From: Fiona Fitzgerald <Fiona.Fitzgerald@arun.gov.uk>
Sent: 30 March 2022 11:54
To: Planning.Responses <Planning.Responses@arun.gov.uk>
Cc: Michael Eastham <Michael.Eastham@arun.gov.uk>
Subject: BE/20/22/DOC

Condition 4 – Lighting

Condition 28 – Acoustic Fencing

Drawing Title:
**ELECTRICAL SERVICES
EXTERNAL LIGHTING LAYOUT**

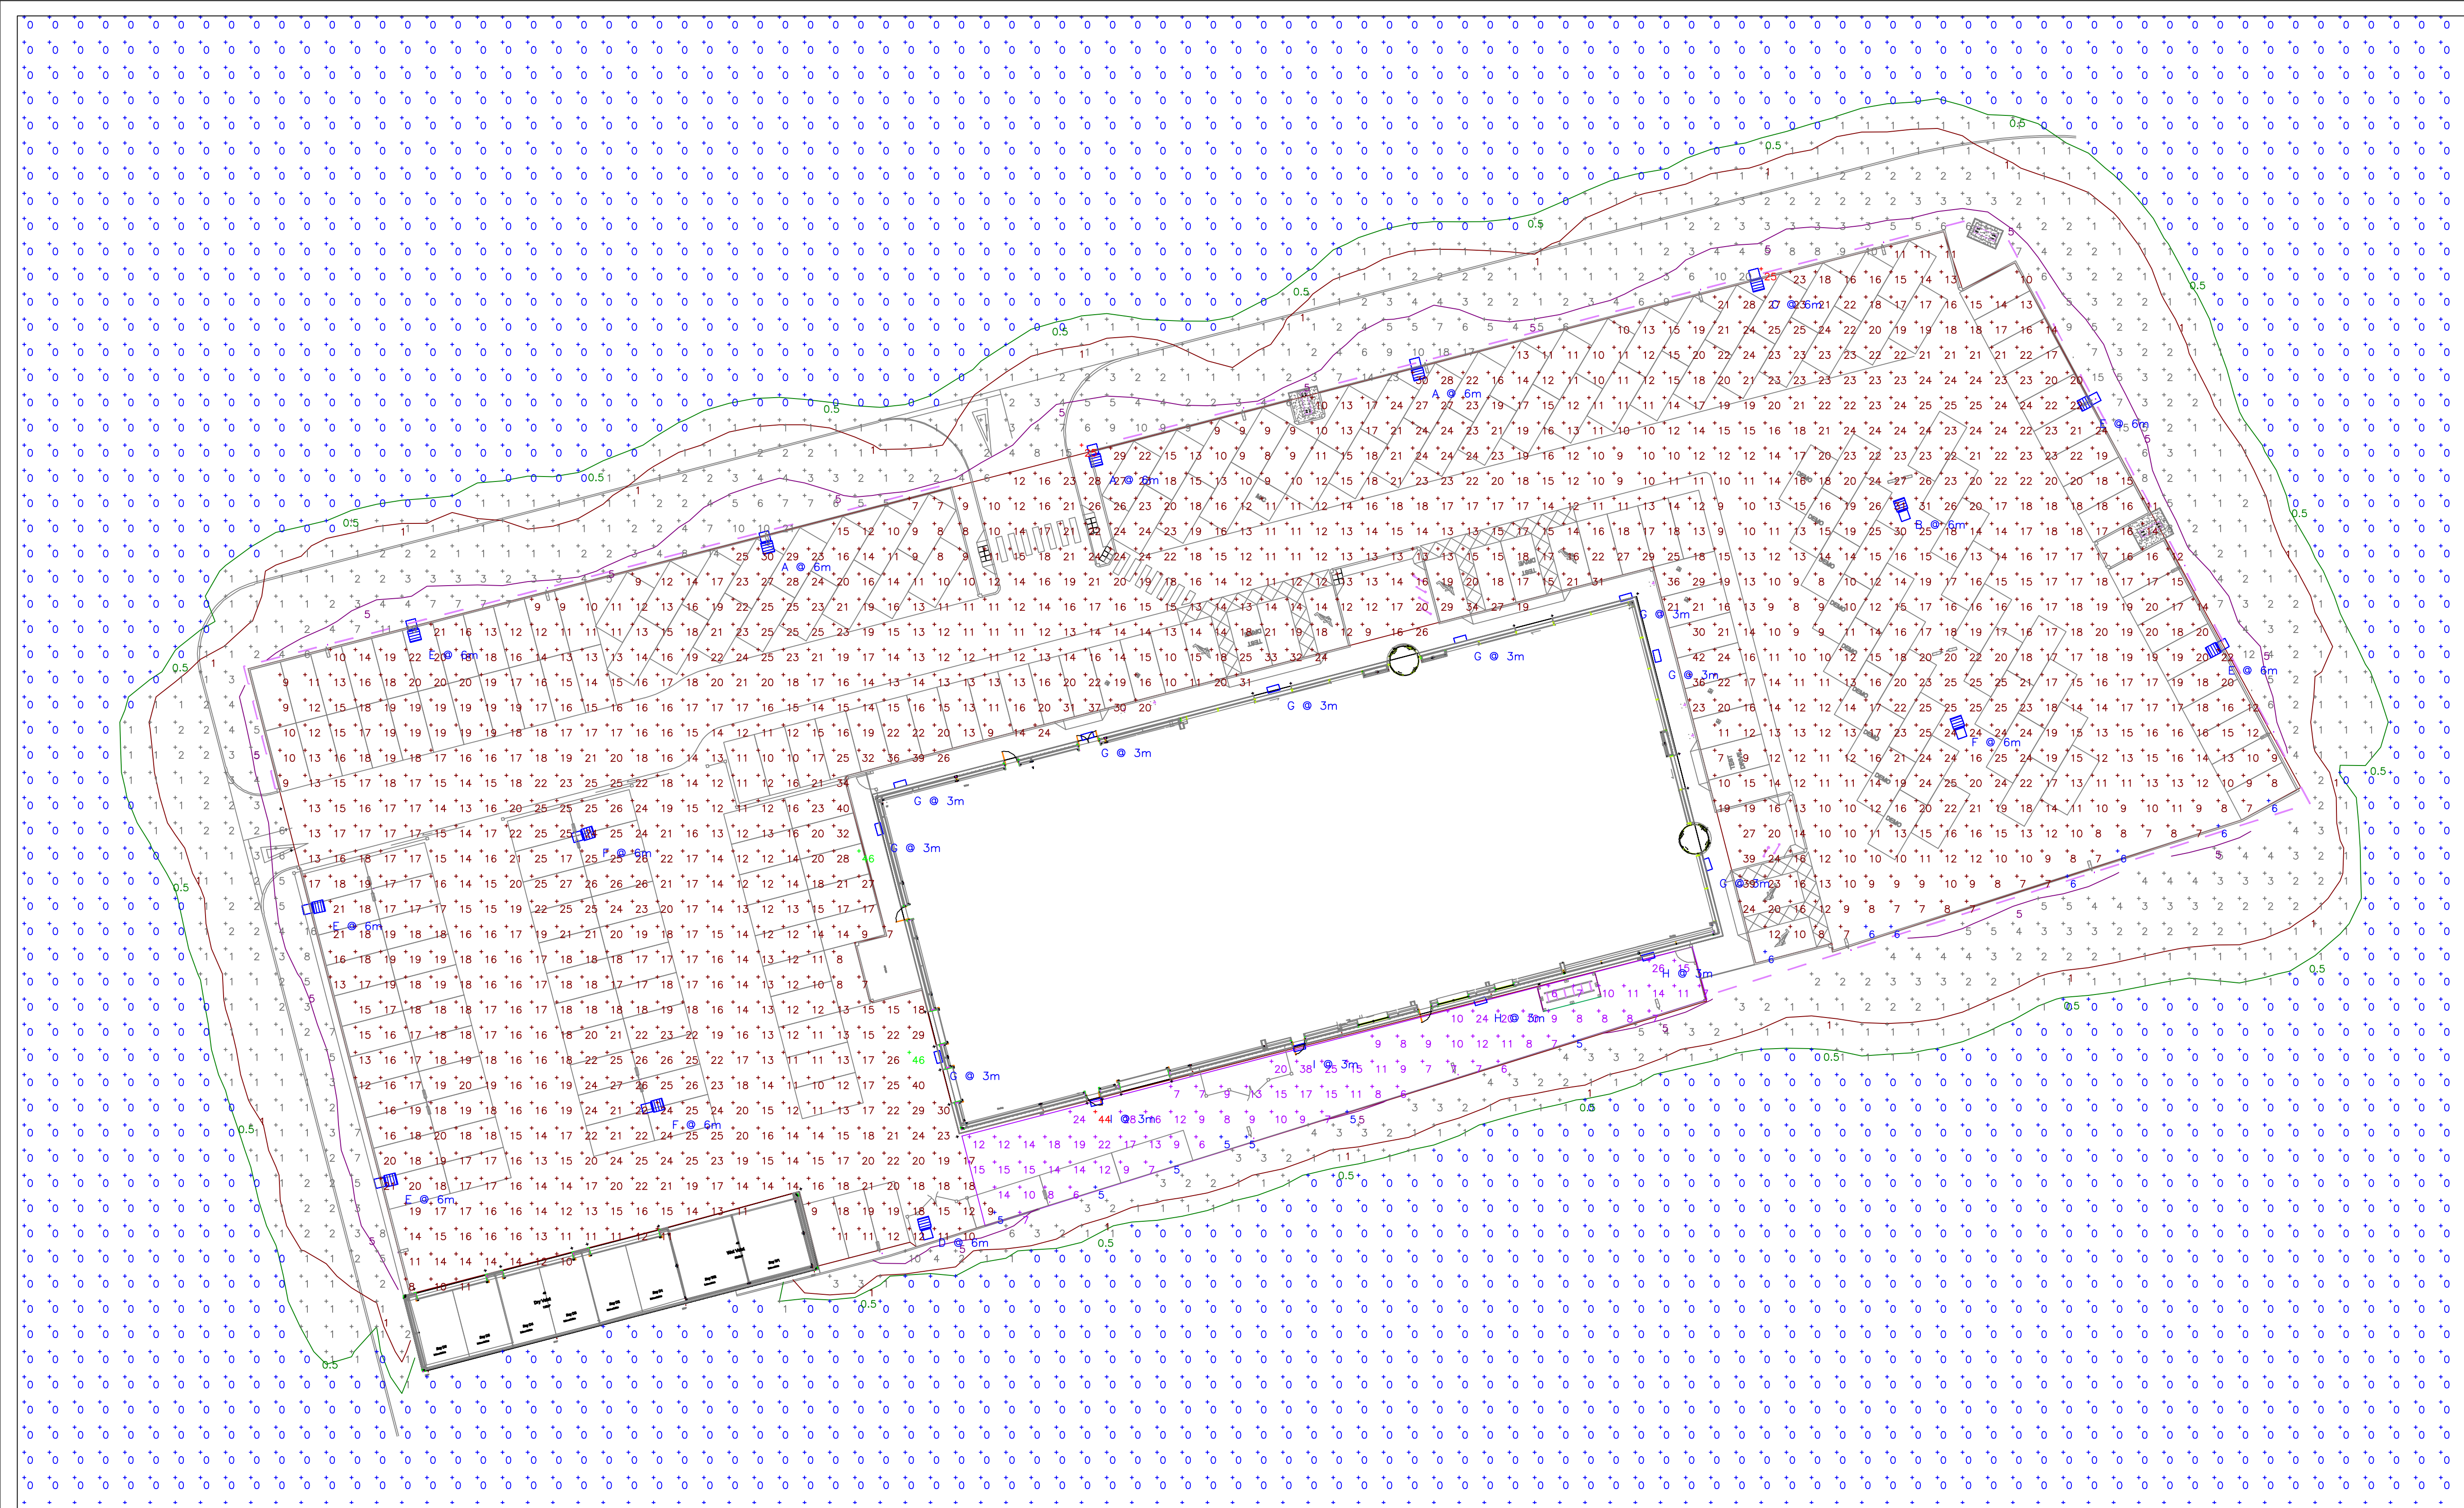
1. Please could the applicant confirm whether or not they have referred to (ILE) Guidance Note 1 for the reduction of obtrusive light 2021 as this does not appear to be stated in the Relevant Standards and Guidance section?
2. The document alludes to the fact that the scheme is consistent with Zone E2 but does not directly state it (last 2 paragraphs on page 5). Please could the applicant confirm whether or not the scheme complies with Zone E2 or not?
